# Sheringham Shoal and Dudgeon Offshore Wind Farm Extension Projects

## Final Statement of Common Ground with National Highways (Revision E)

Revision E  
Deadline 8  
July 2023  
Document Reference: 12.22

▨ VEHICLE BODY SWEEP PATH (FORWARD GEAR)  
 — VEHICLE CHASSIS SWEEP PATH

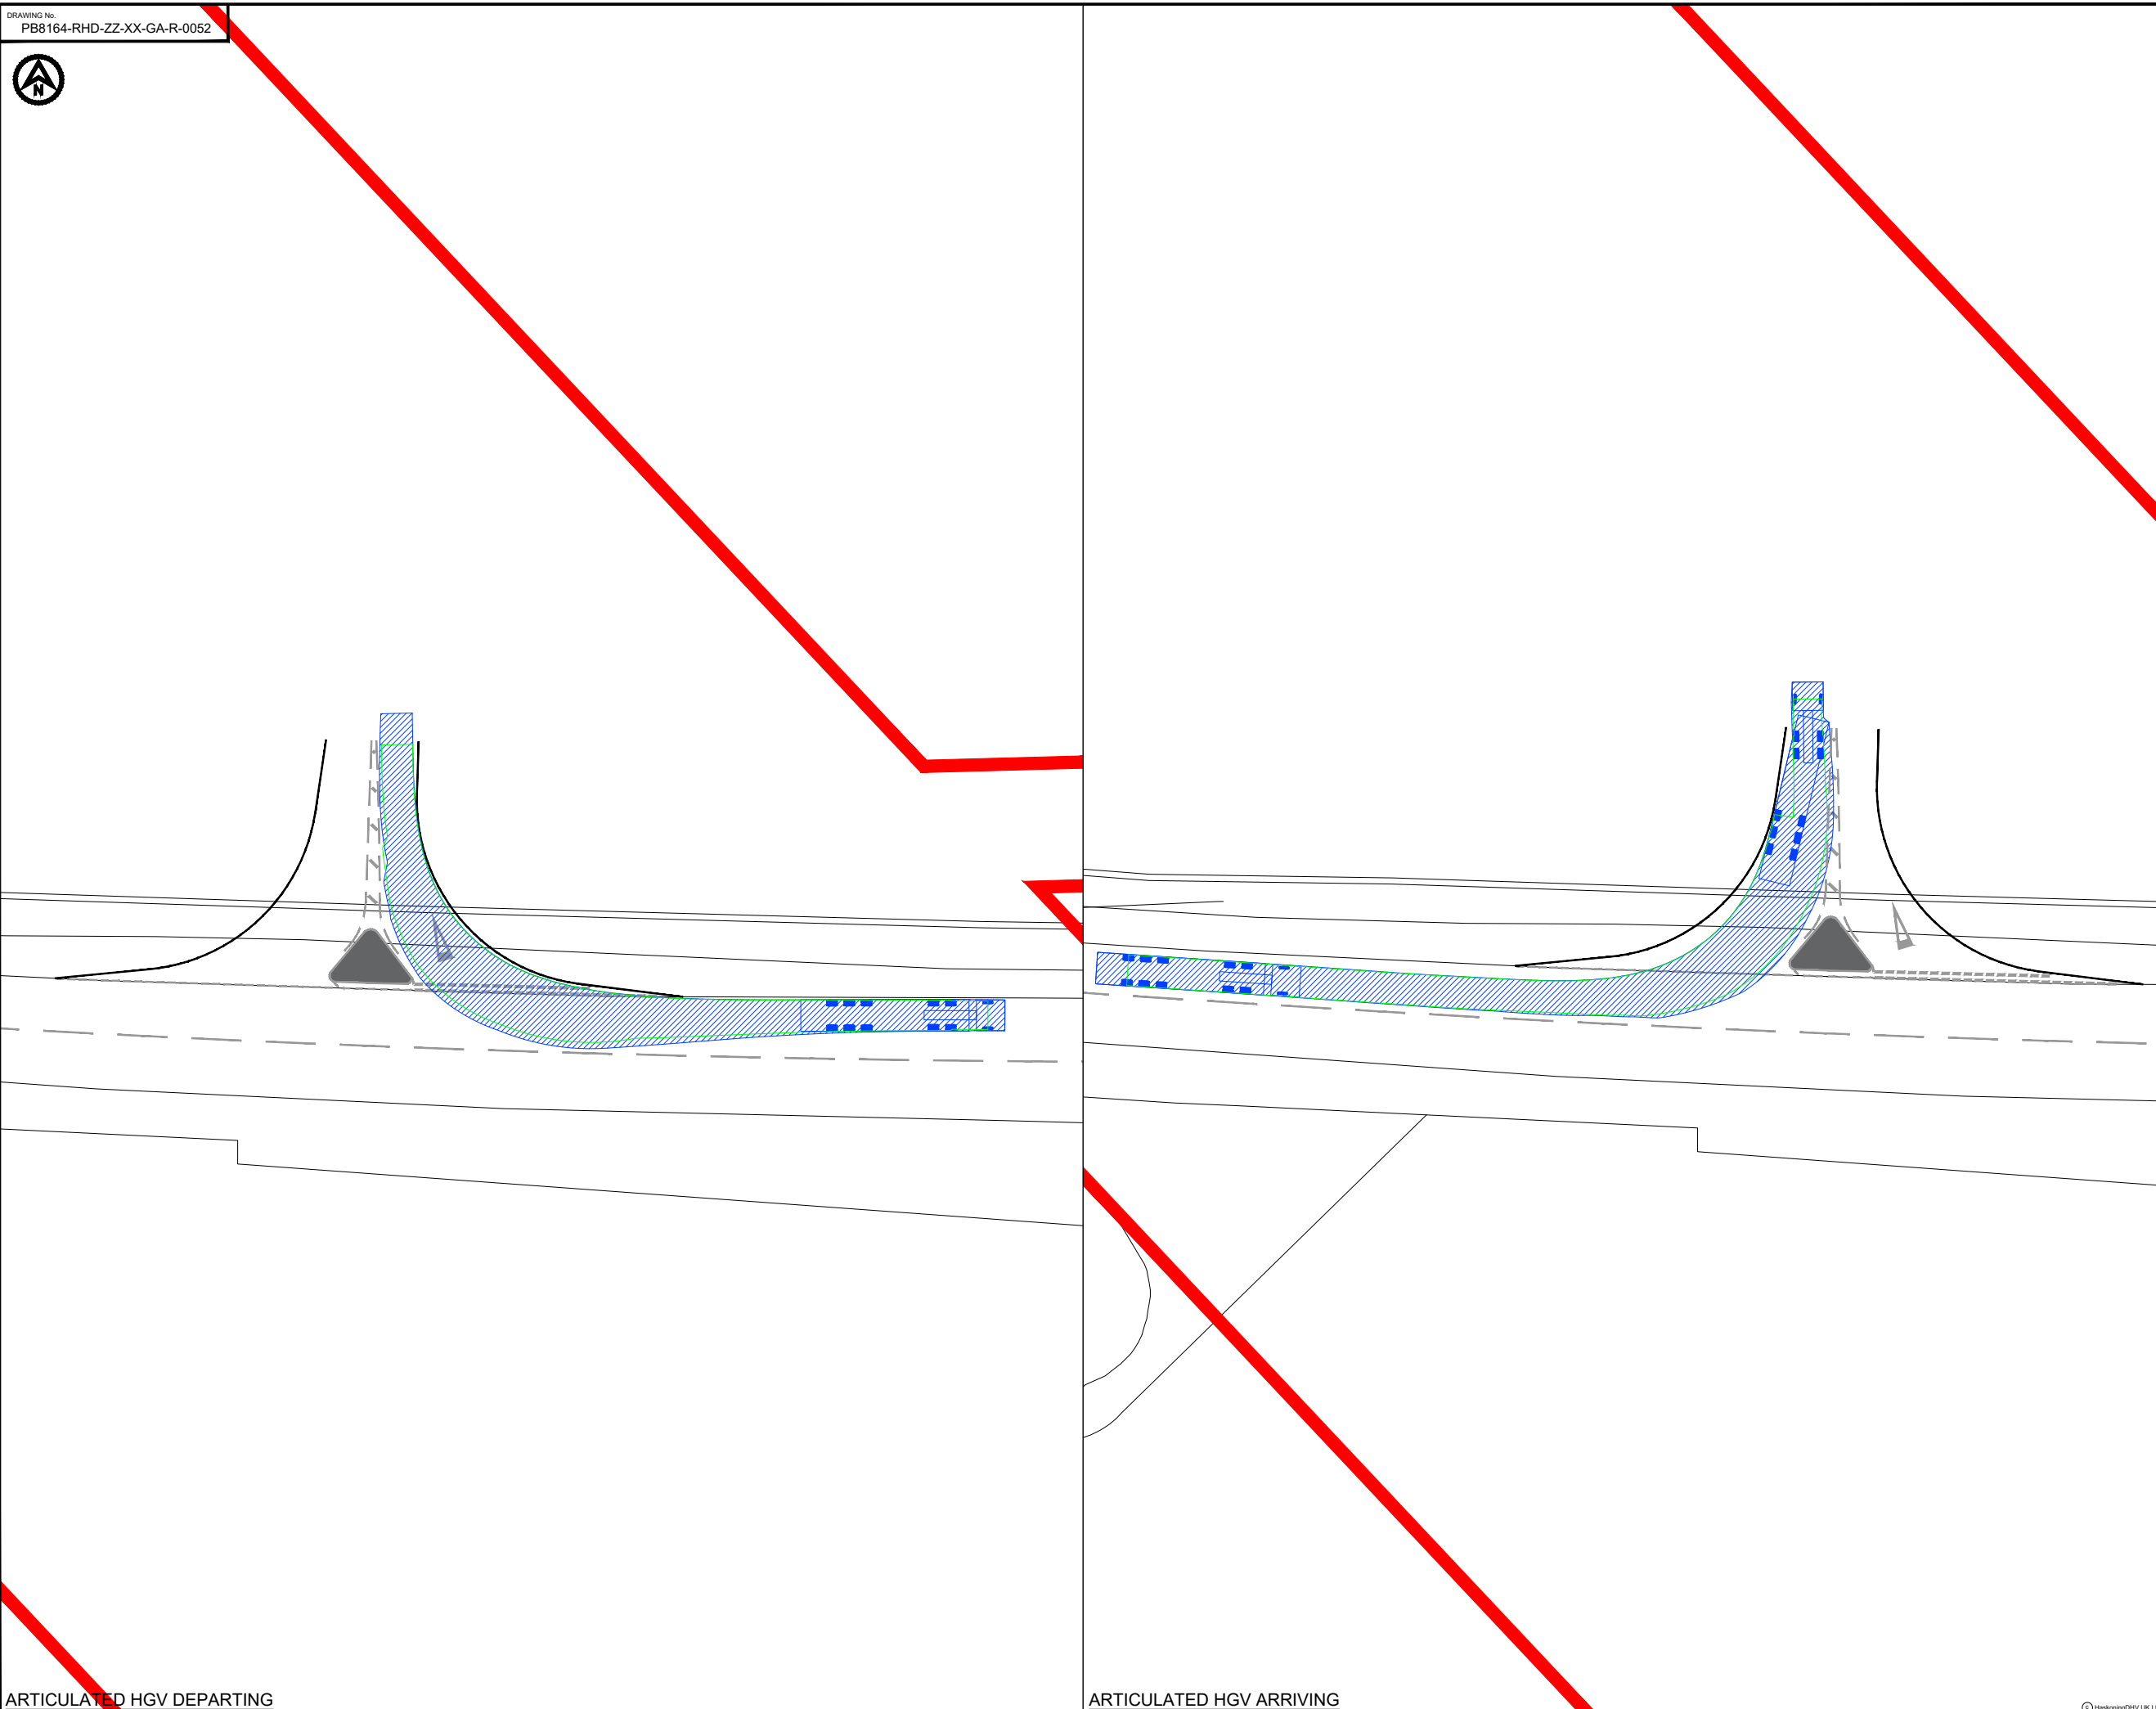
23	The outline design for an access off the A47 is appropriate, as presented in Annex 30 of the Transport Assessment [APP-268 and APP-269]	National Highways agree that the outline design for an access off the A47 (ACC47) is appropriate subject to Stage 1 and 2 Road Safety Audits being carried out post consent. Please note that this access is only usable until the A47 Tuddenham scheme starts construction, or if the A47 Scheme does not go ahead.	<i>Agreed</i>
<b>EIA – Cumulative Impact Assessment (CIA) Conclusions</b>			
24	Cumulative impacts assessment with other windfarms, as presented in Section 24.7 of ES Chapter 24 Traffic and Transport [APP-110], is appropriate based on currently available information and proposed mitigation, impacts are not significant in EIA terms.	National Highways agree that the cumulative impacts assessment with other windfarms, in relation to effects on traffic along the SRN, as presented in Section 24.7 of ES Chapter 24 Traffic and Transport [APP-110], is appropriate based on currently available information and proposed mitigation, impacts are not significant in EIA terms.	<i>Agreed</i>

29	The access concept design for access ACC47 is appropriate and that detailed access designs can be developed and agreed with National Highways prior to the start of construction, secured under Requirement 16 of the draft DCO [AS-009].	National Highways agree that the access concept design for access ACC47 is appropriate, subject to Stage 1 and 2 Road Safety Audits to be carried out post consent, and that detailed designs can be developed and agreed with National Highways	<i>Agreed</i>
